Subject: RE: Highways England response re. application A/122/19/OUT - Land off Arundel Road

Planning Application No: A/122/19/OUT

Site: Land off Arundel Road, Angmering, BN16 4ET

Highways England Planning Response (HEPR 16-01)

T:\Projects\19020 Series Project Numbers\19020 TEL Land at Angmering, Ang Dist, W Sussex\Tech\Local Transport Drawings\Working Drawings\GA\ITB9105-GA-024B.dwg

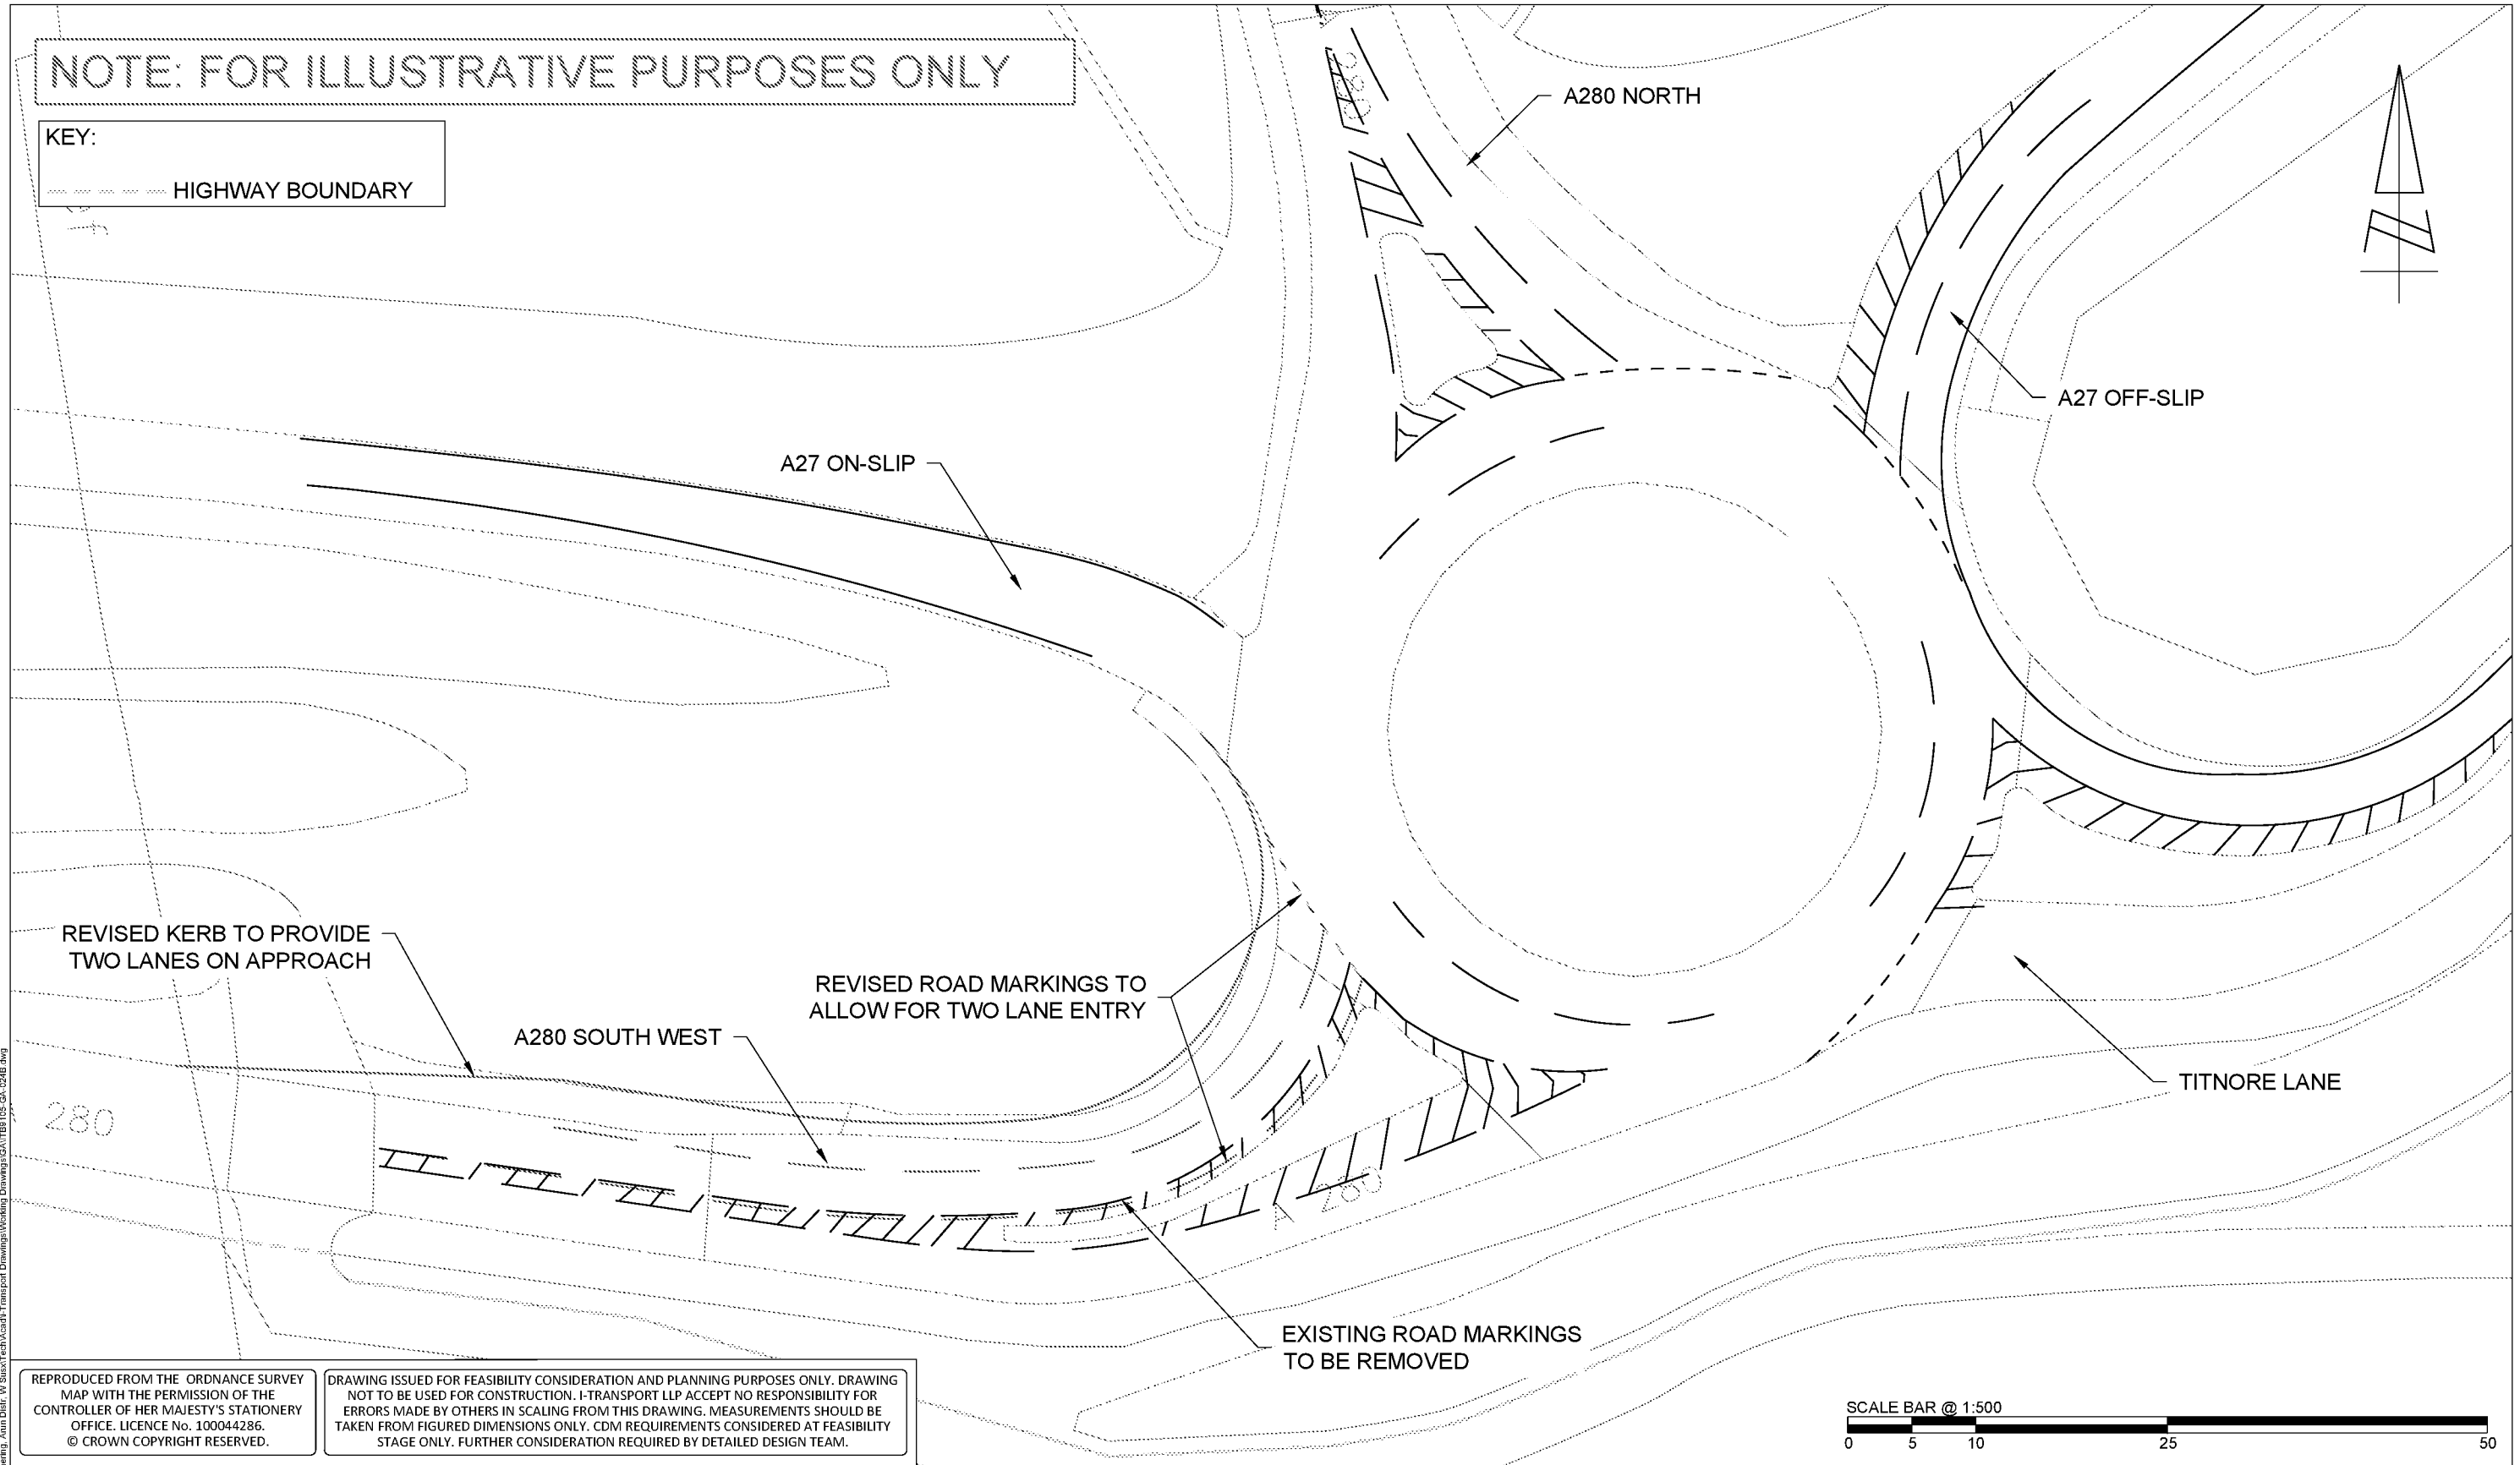
- 1) Prior to the occupation of 80 dwellings within the permitted development, the improvement works at the A280/A27/Titnore Lane Roundabout junction shall be completed and open to the travelling public as shown on i-Transport's drawing number "ITB9105-GA-024 – *Proposed Improvement Scheme to A280/A27/Titnore Lane Roundabout*" (or such other scheme of works substantially to the same effect, as may be approved in writing by the local planning authority (who shall consult with Highways England)), including any necessary transfer of lands to enable the construction and maintenance of the scheme.

DRAWING NUMBER: **2020-06**

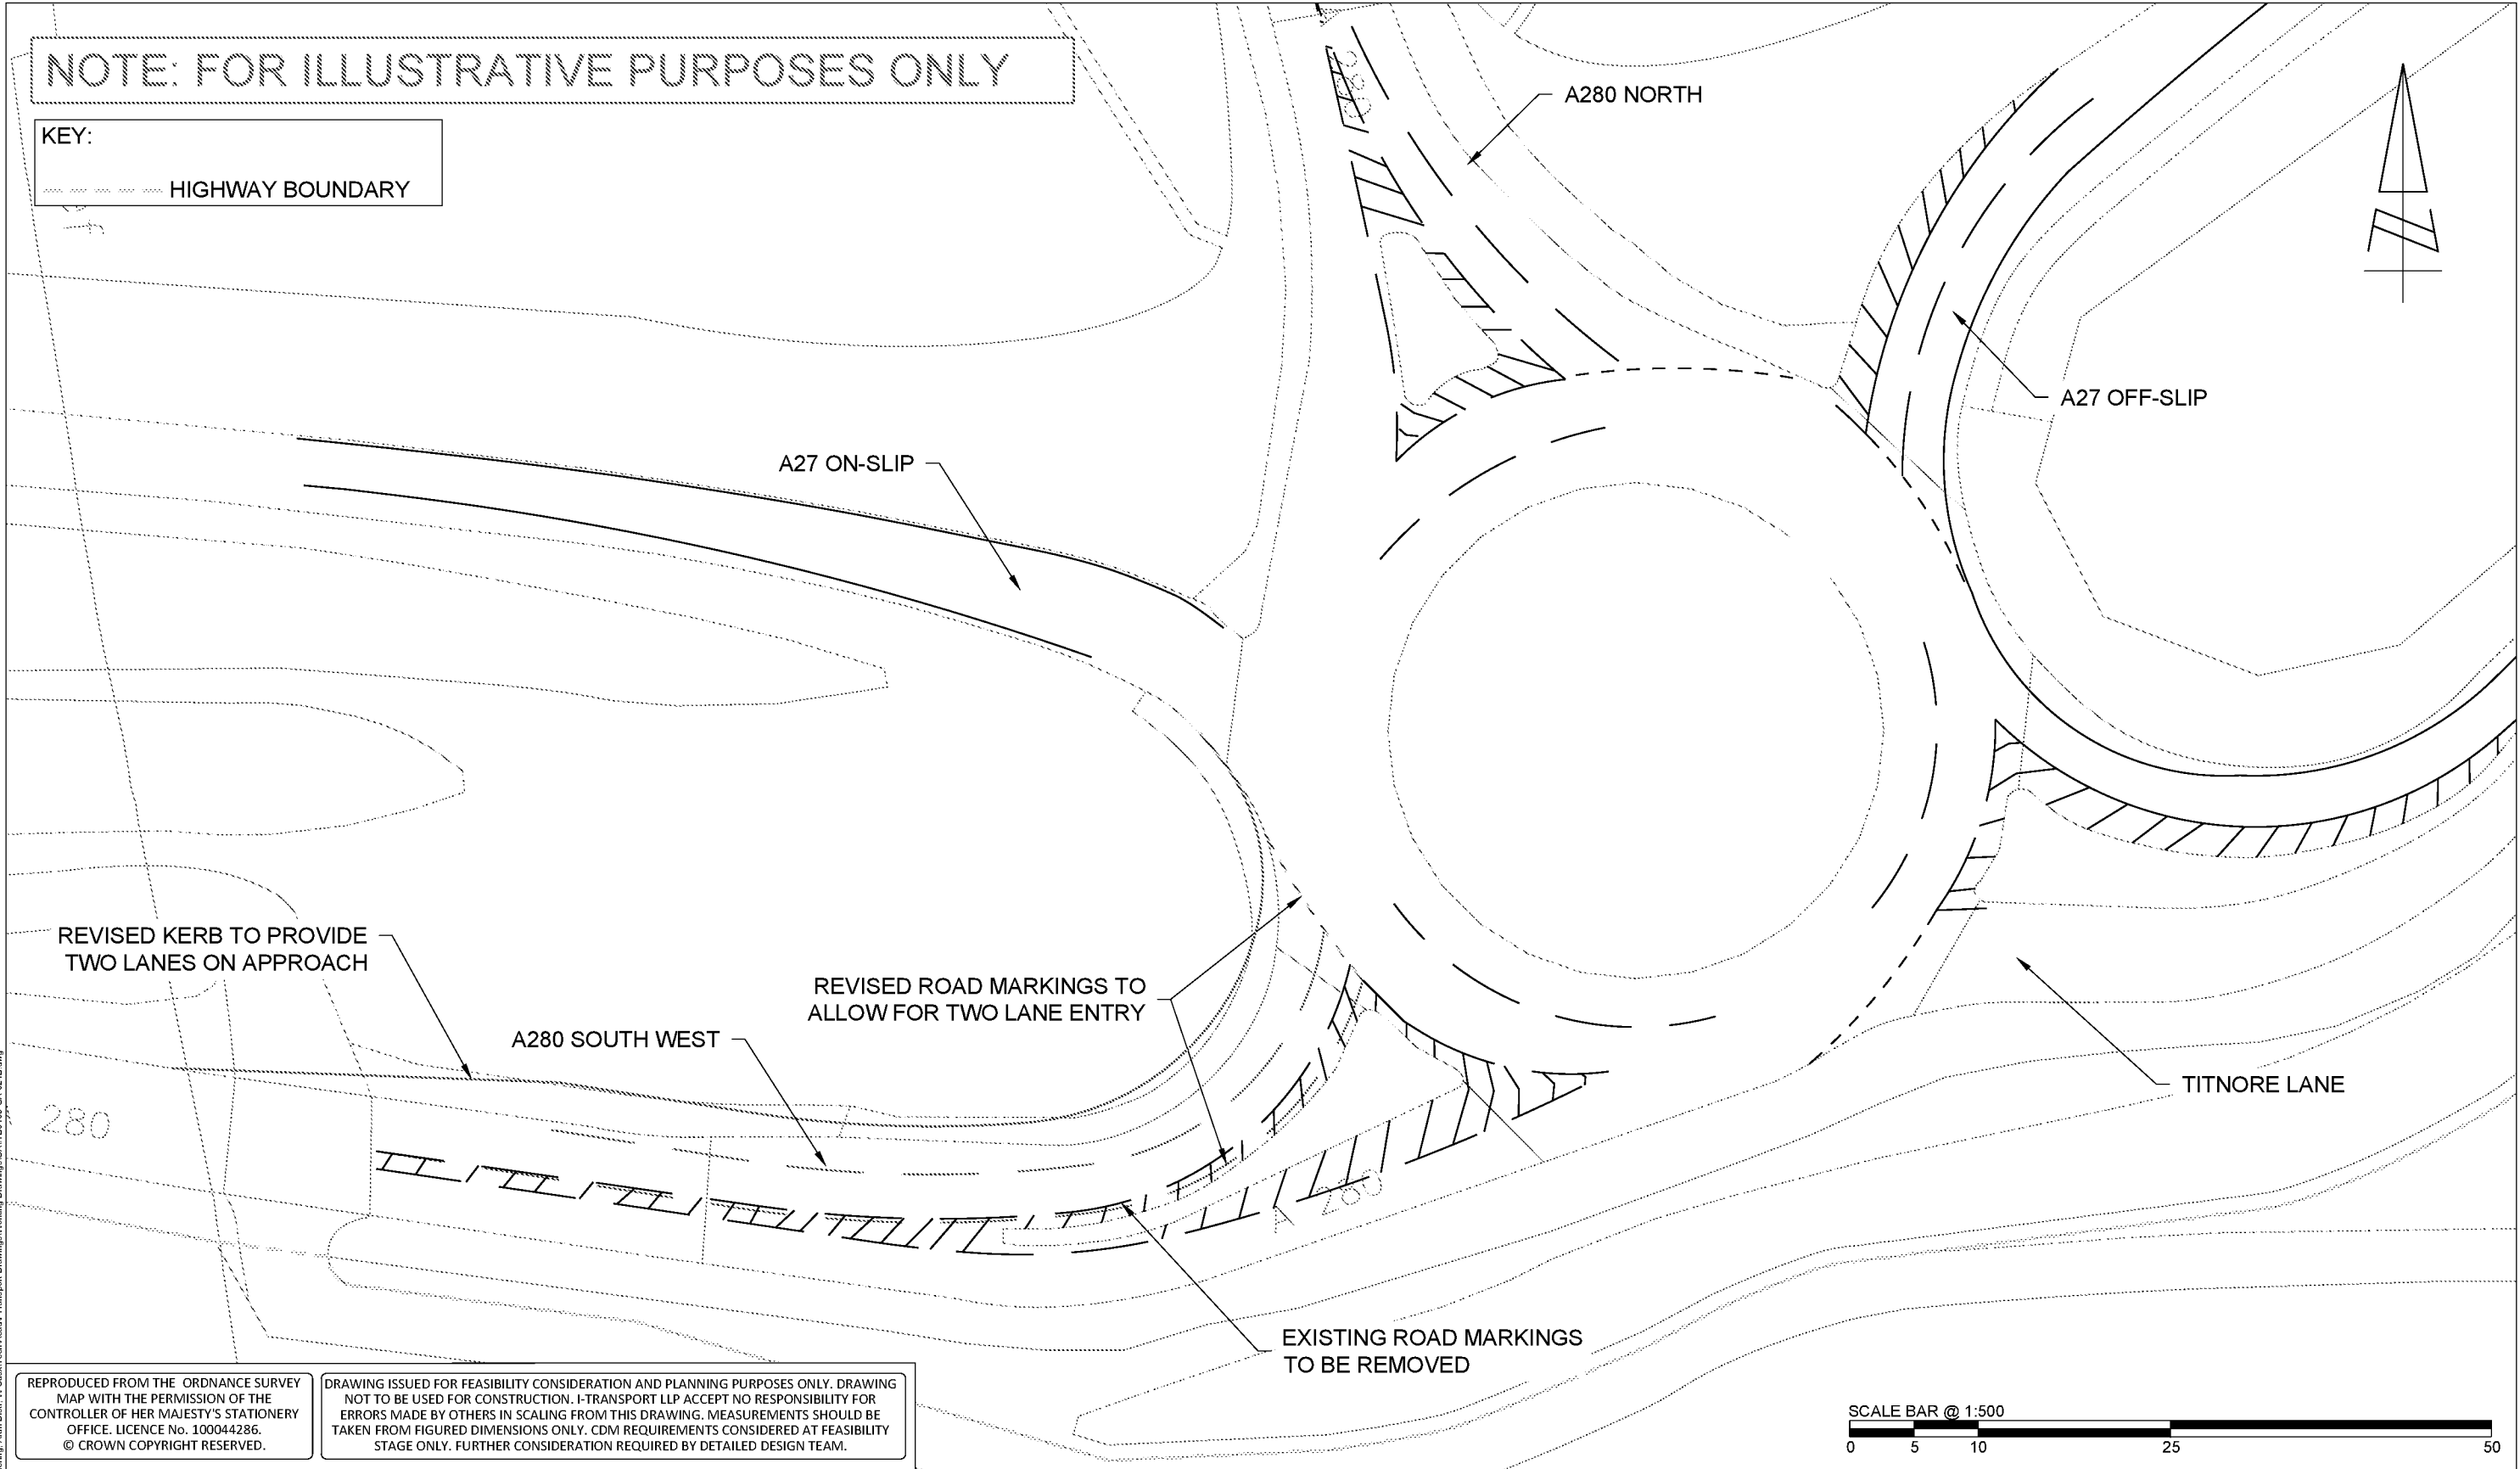
- 2) Prior to the occupation of 80 dwellings within the permitted development, the proposed improvements to the existing pedestrian crossing points on the A27 shall be completed and open to the travelling public as shown on Croft's drawing number "2020-06 – *Proposed Improvements to existing pedestrian crossing points on A27*" (or such other scheme of works substantially to the same effect, as may be approved in writing by the local planning authority (who shall consult with Highways England)), including any necessary transfer of lands to enable the construction and maintenance of the scheme.
